**MODIFICATION REQUEST:  
Internal and External Design Changes  
and Amendment to Conditions to Dr  
Chau Chak Wing Building  
14-28 Ultimo Road, Ultimo  
(MP09\_0153 MOD 3)**

Director-General's  
Environmental Assessment Report  
Section 75W of the  
*Environmental Planning and Assessment Act 1979*

April 2013

SPRINKLER
TANK RL
UPDATED

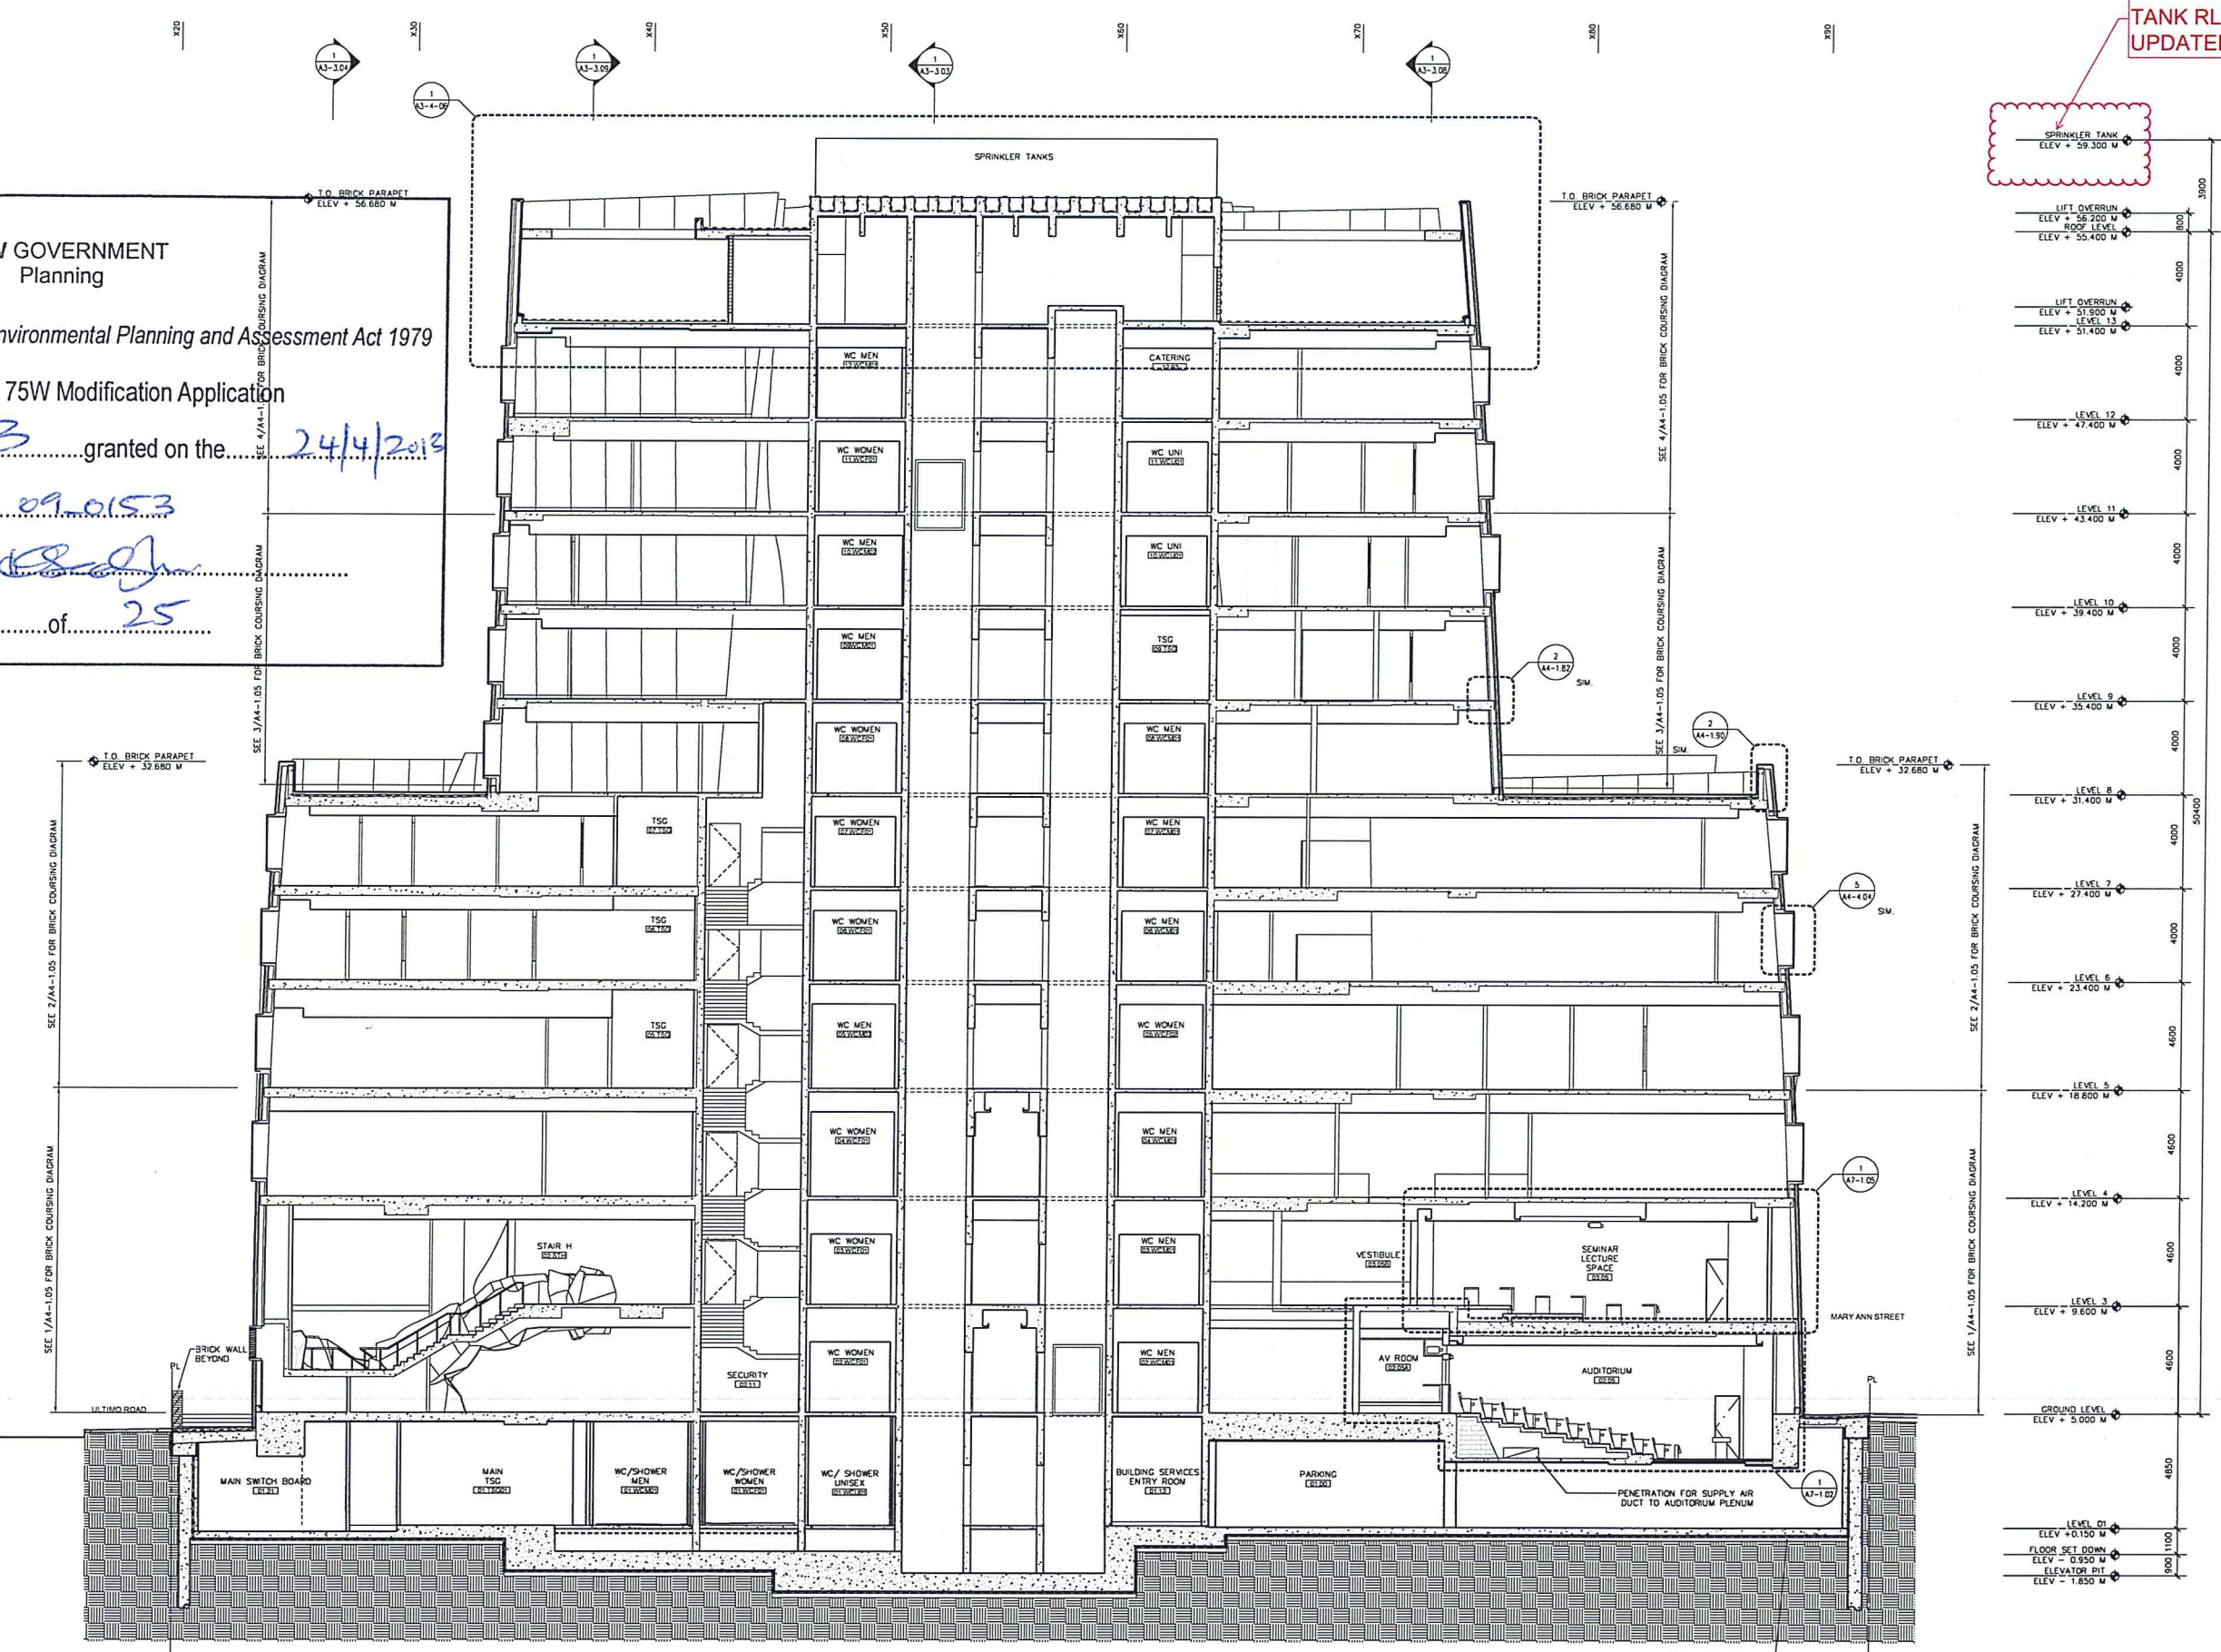
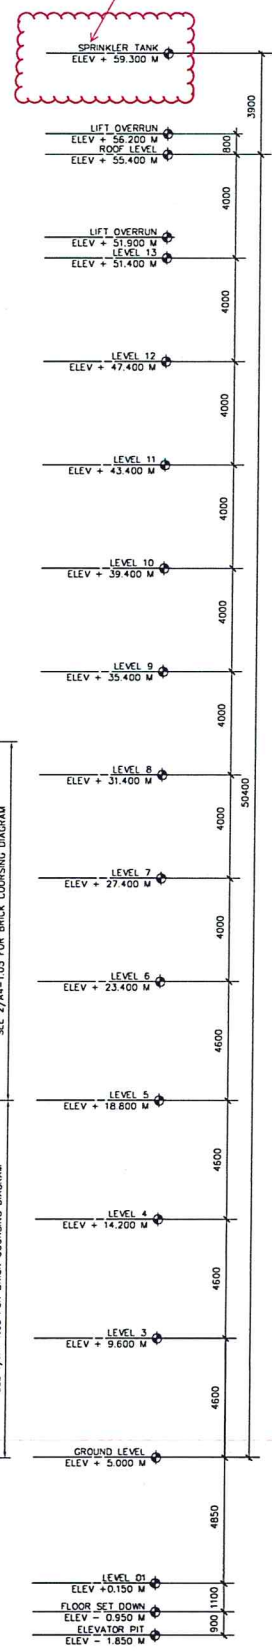
The approved building height, inclusive of the sprinkler tank on roof level, is RL 58.70. The proponent seeks a slight increase to RL 59.30. The modification request is the result of adding 600 mm structural piers to support the sprinkler tank.

The approved building was considered to have an acceptable level of overshadowing impact on adjoining properties during the winter solstice. The department considers the minor height increase would have no further reduction in sunlight entering surrounding buildings as the additional shadow would only be created on the roof. In addition, no visual impacts would arise from the minor height increase of the sprinkler tank as it will be adequately obscured from public view due to its setback from the building façade. **Figure 5** depicts the setback of the sprinkler tank that may be perceived from Ultimo Road and Mary Ann Street.
